AL/100/07/AG**AGRICULTURAL REPORT**

DESCRIPTION/ ADDRESS	- Prior notification for construction of clay lined reservoir for the storage of abstracted water for subsequent spray irrigation purposes Land at rear of Park Farm, Aldingbourne
-------------------------	---

AL/100/07/AG

| /Gillbard/Reservoir plan2.dwg                                                       |                                  |       |            |

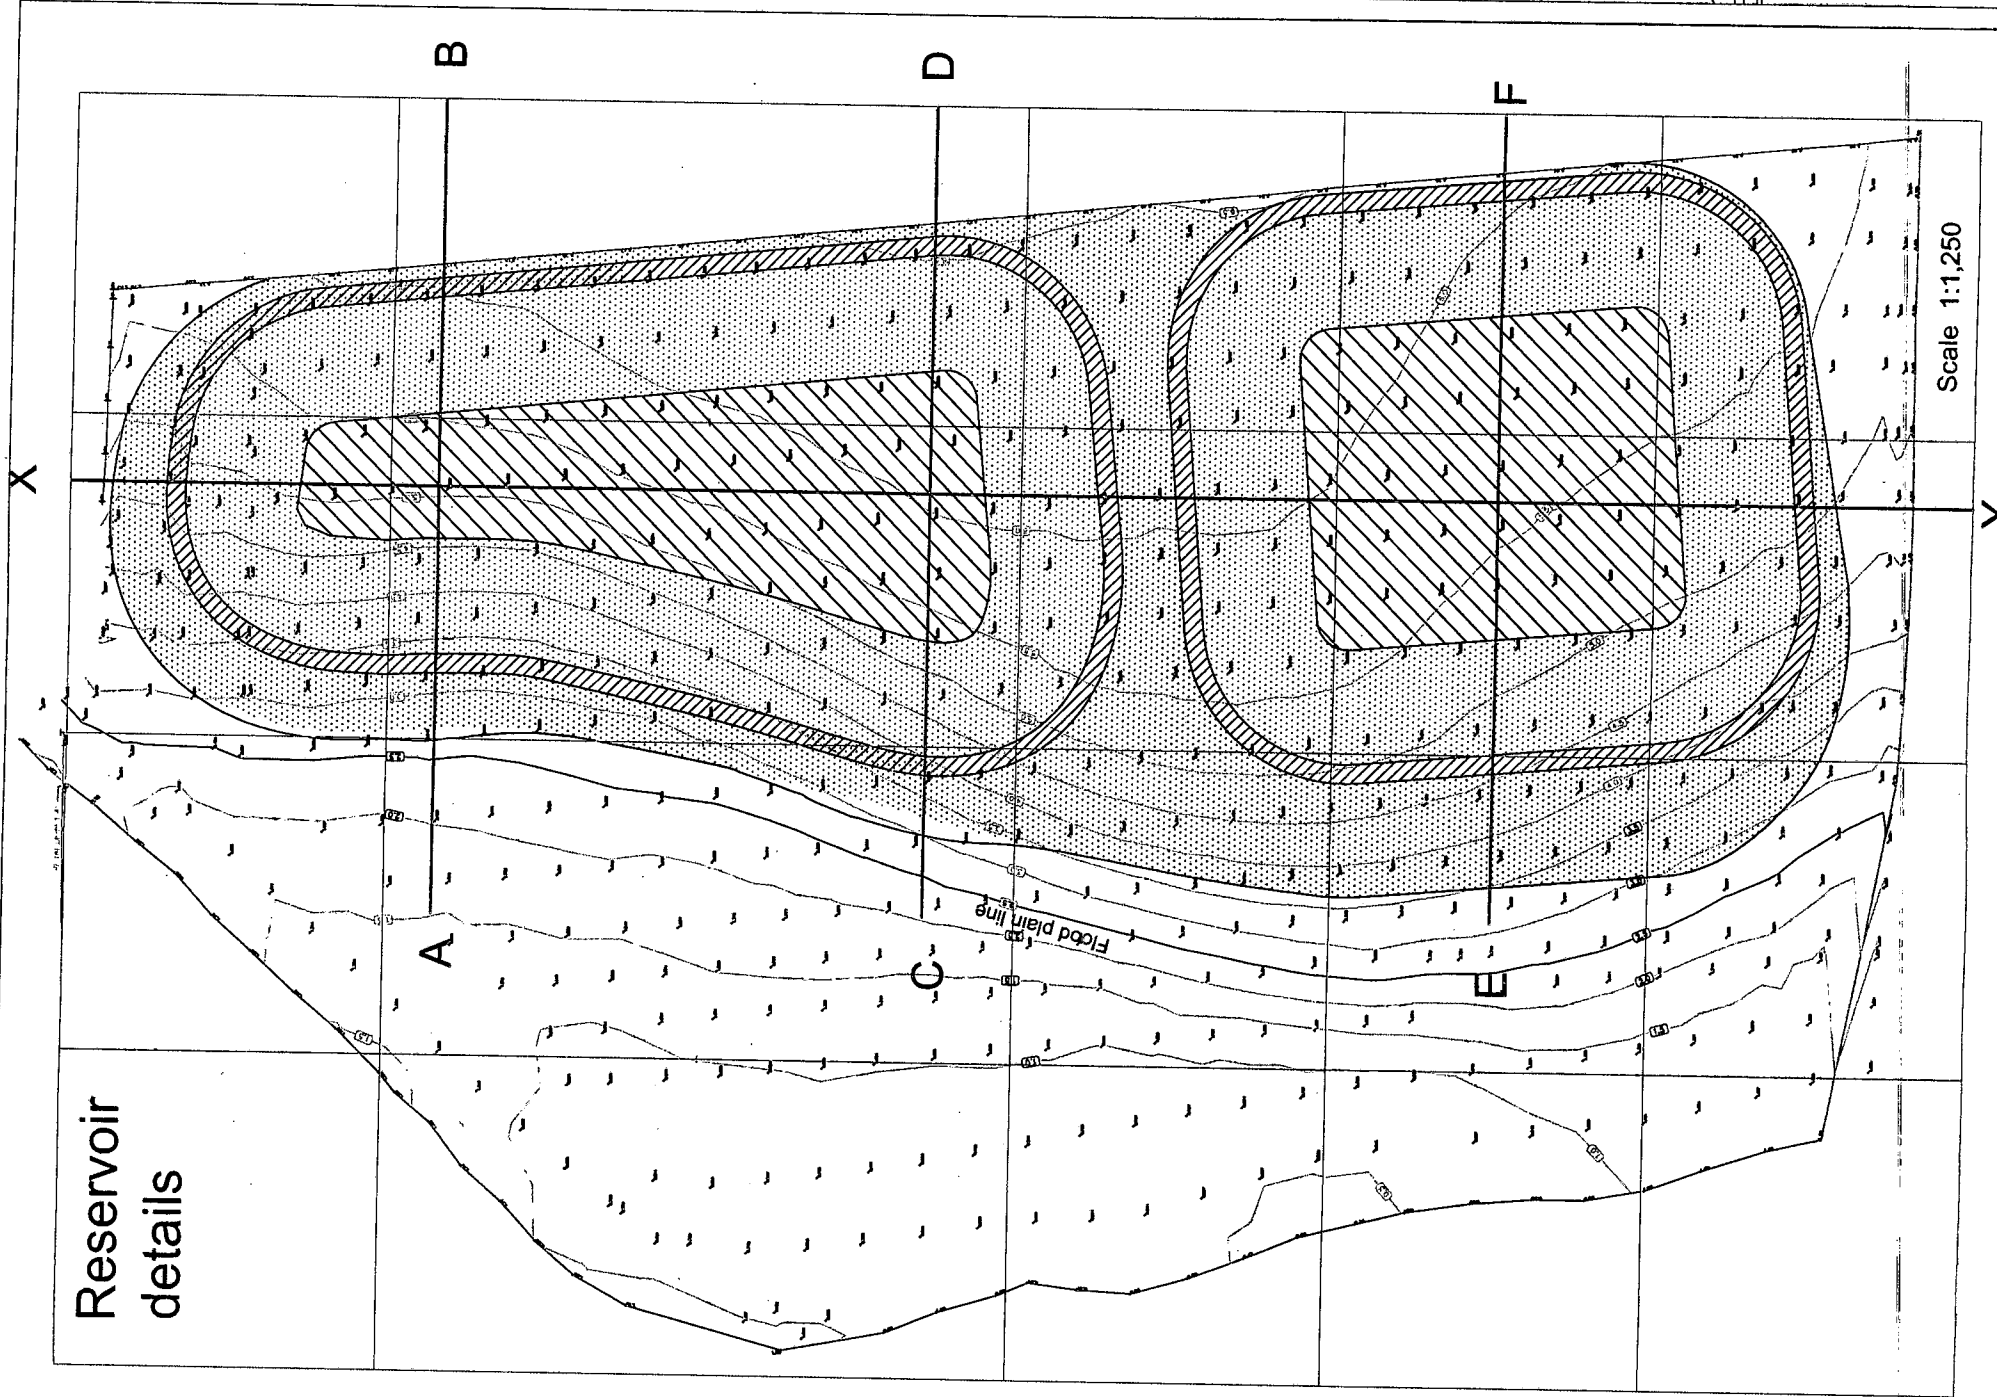
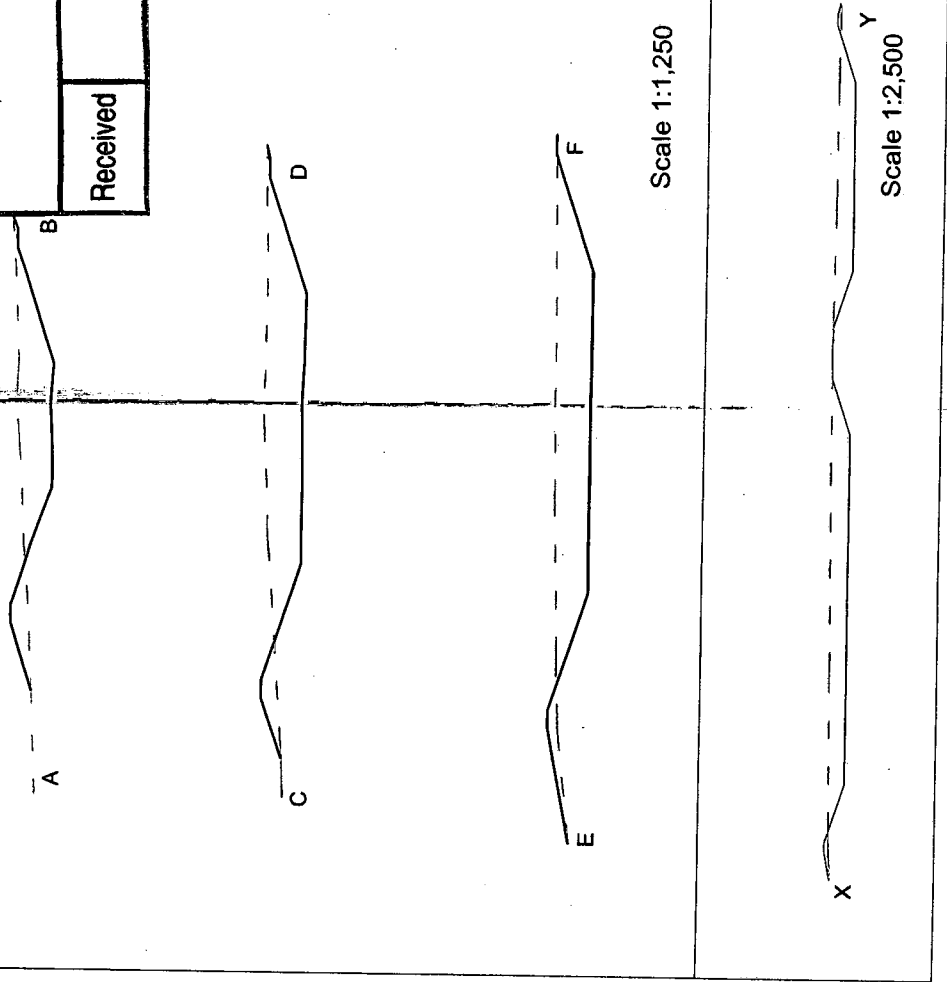
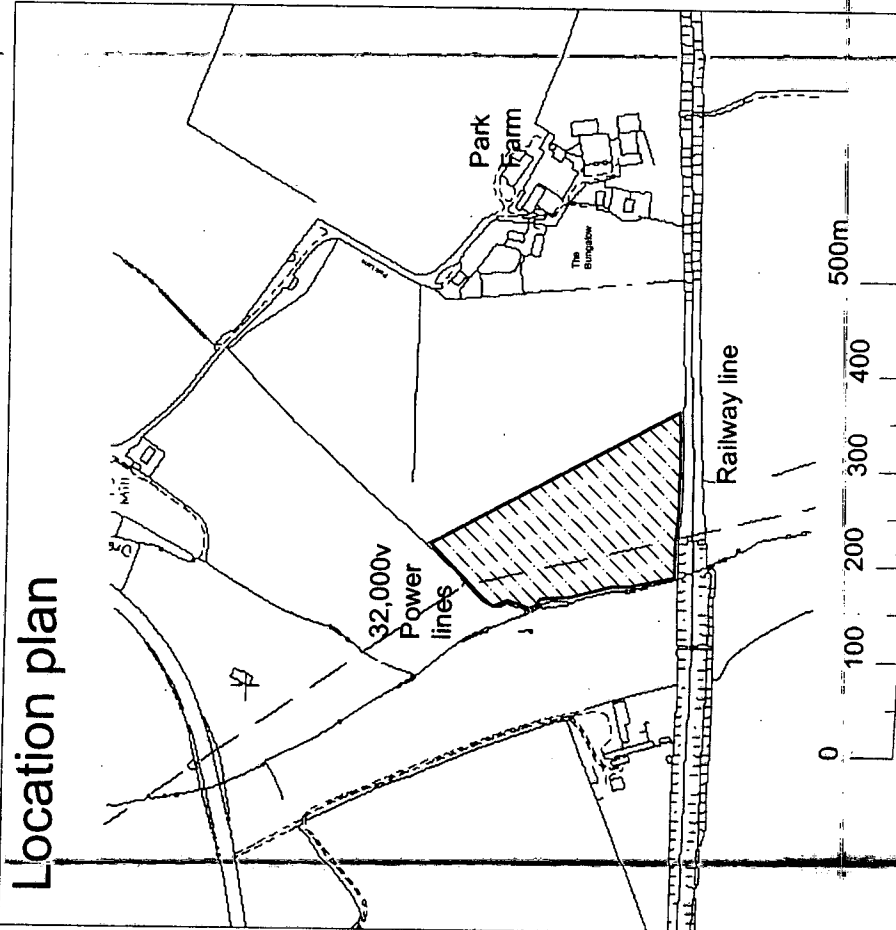
CONSULTEE	SUMMARY OF RESPONSE
District Engineers	The proposal appears to be below ground, however, drawing "Gillbard Reservoir plan 2 dwg" does not confirm this. It is noted in the enclosed letter from the Environment Agency that it is likely to grant an abstraction licence for next Spring, presumably for Winter 2008.

The proposal does not supply any details of landscaping or earth movement details such as ground levelling, and bank details. There is no Flood Risk Assessment which would be required in the flood zone or details of a buffer strip.
